| Application number: 2021/90148   |                                                                                  |
| What is the application for?:    | Erection of extensions and alterations to existing dormer bungalow to create two |
| Address of the site or building: | 5, Inglewood Avenue, Birkby, Huddersfield, HD2 2DS                               |

./ DRAWING TITLE
PROPOSED GROUND
FLOOR PLAN
./ DRAWING
STAGE
PLANNING

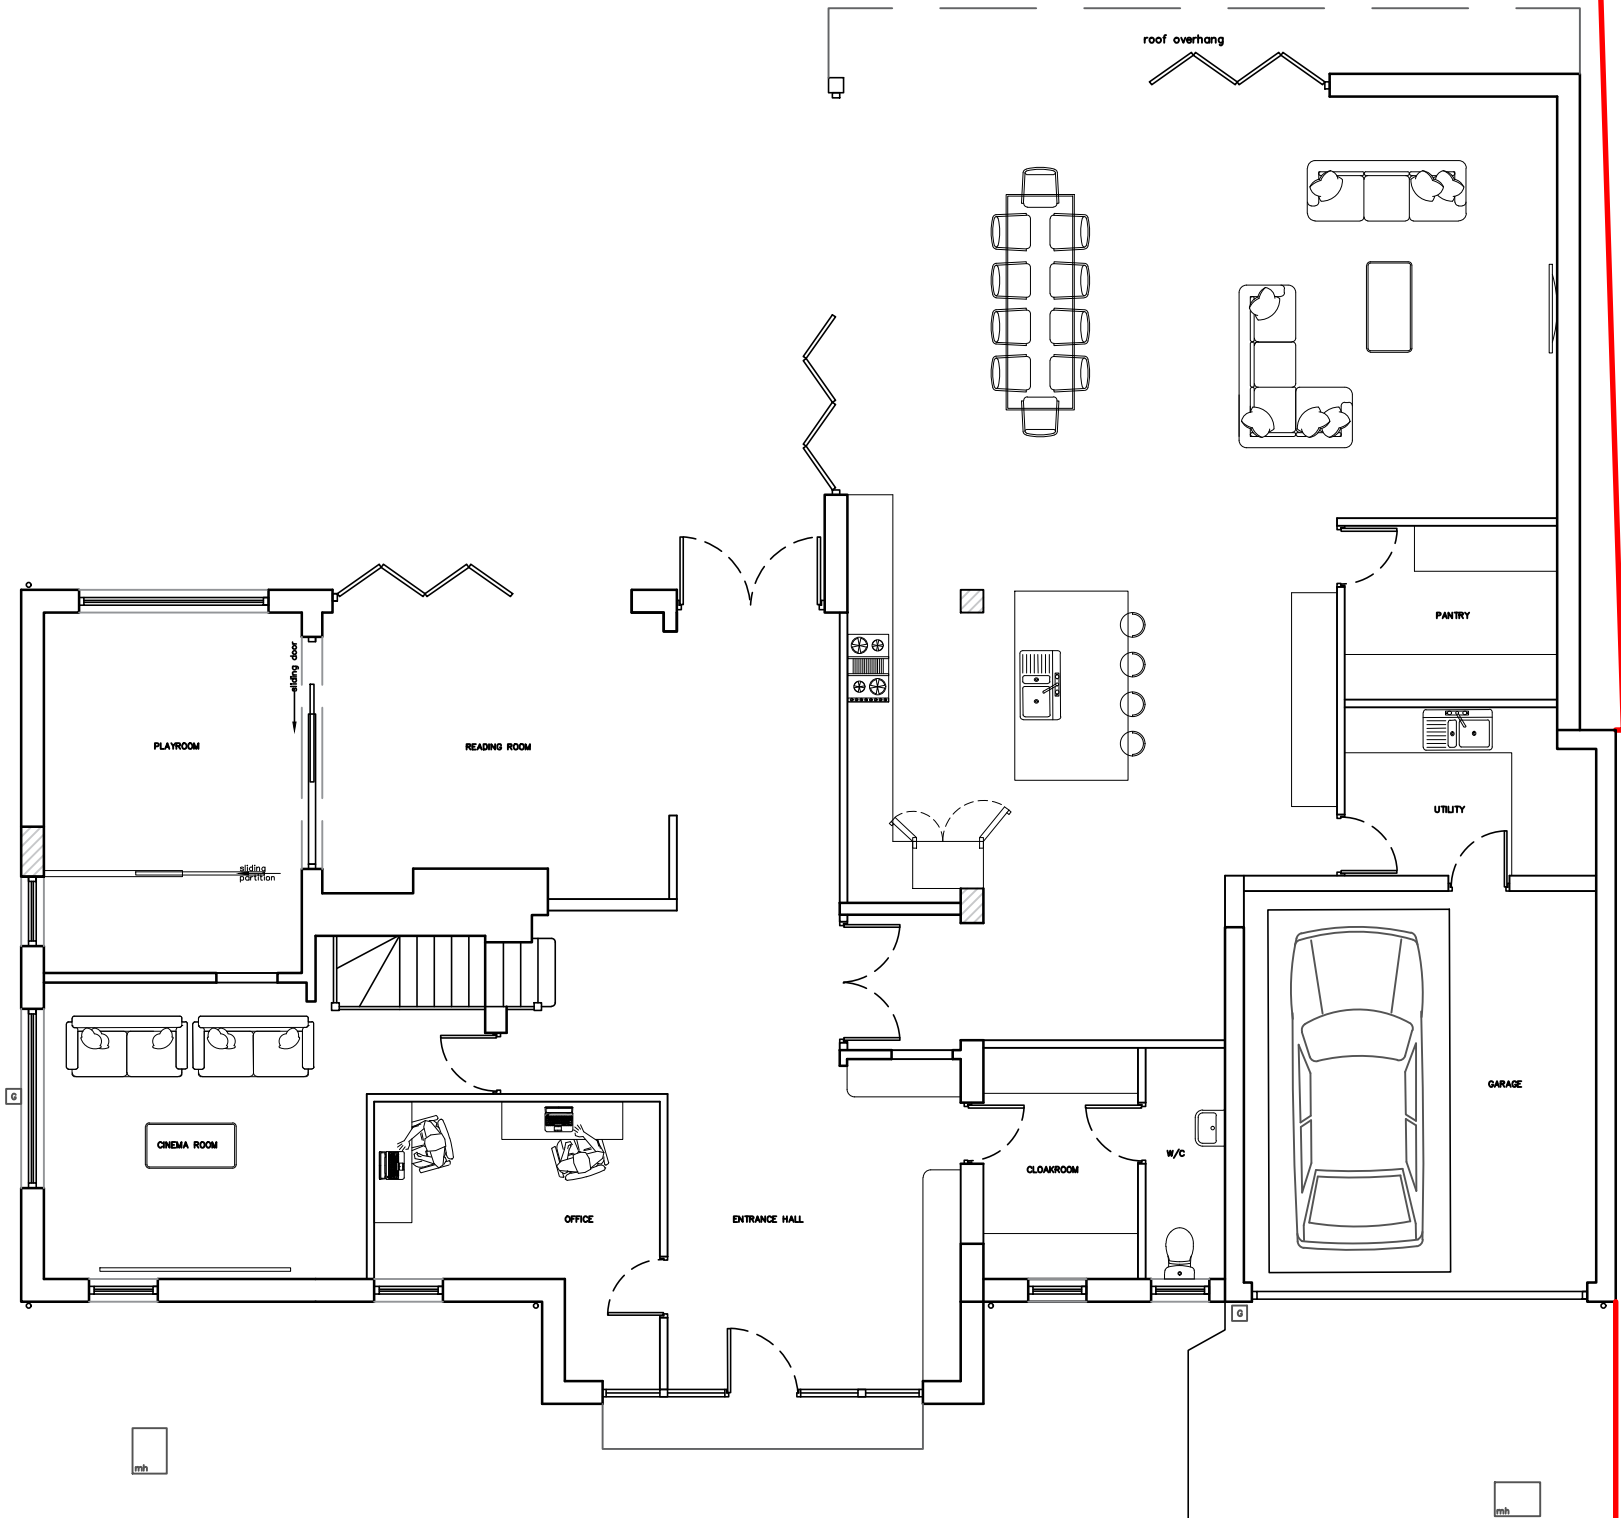
| <p>We have been asked by our client to add a further comment. He has originally asked for the rear extension to set back circa 2m from the side boundary is to also respect the existing leyandii hedges and safeguard their roots along the site boundary. In this way the soft landscape will be retained and allow a better soft screening rather than a view of a brutal blank wall of the extension. The privacy needs to be respected.</p> |     |
